MEMORANDUM

TO: Nell Donaldson, Planner
FROM: David Senus, P.E.
DATE: April 7, 2015
RE: 195 Kennebec Street, Level II Site Plan Application

Documents Reviewed by Woodard & Curran

DRAWN: DED	DATE: 11.25.14
DESIGNED: ADJ	SCALE: 1" = 20'
CHECKED: ADJ	JOB NO.: SP-M160
FILE NAME: SP-M160 BASE	
SHEET: C-4.0

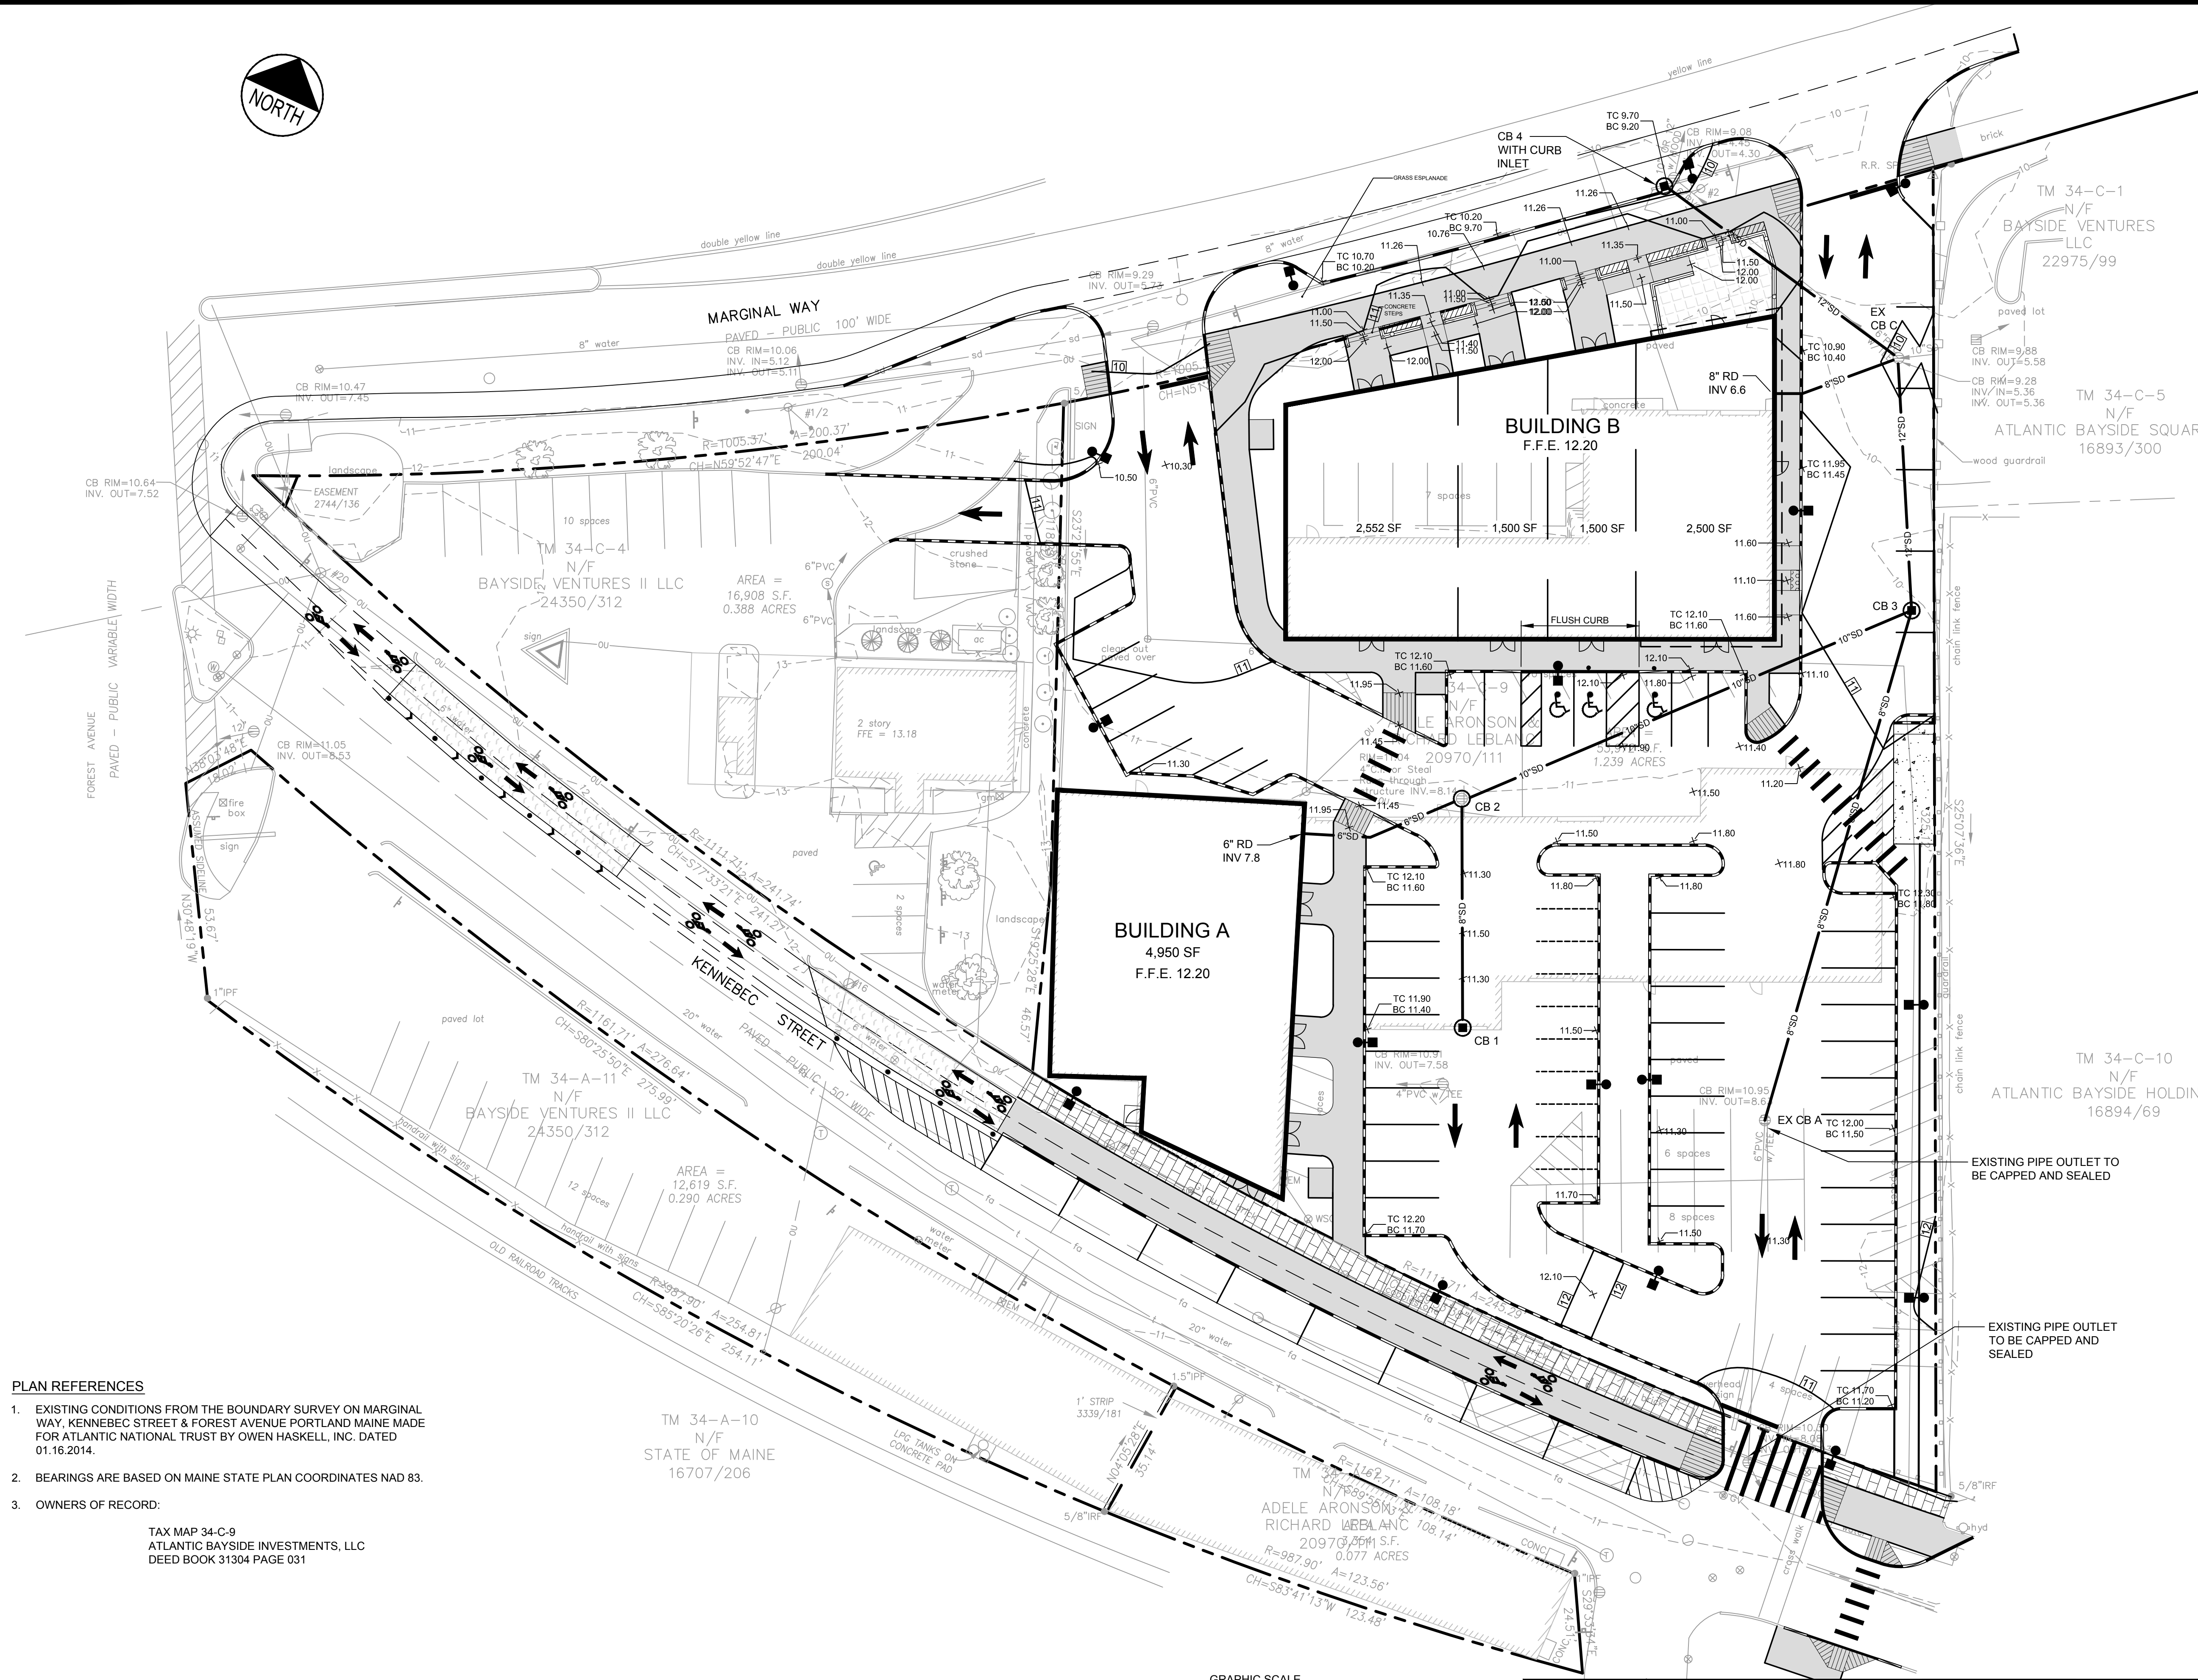
- 1) As requested, the plans have been revised to show a connection from existing Catch Basin A to new Catch Basin 3, which will discharge to Marginal Way. Additional notes are required regarding the abandonment of the pipe between Existing Catch Basin A and the existing catch basin in Kennebec Street. The pipe and catch basin penetrations should be capped at Catch Basin A and at the connection in Kennebec Street; and preferably the pipe is removed or infilled with a flowable fill.
- 2) The revised Sheet C-5.0 Erosion and Sediment Control Plan no longer includes the erosion and sediment control practices that were identified on the originally submitted plan. This plan should be revised to reflect the original submittal.
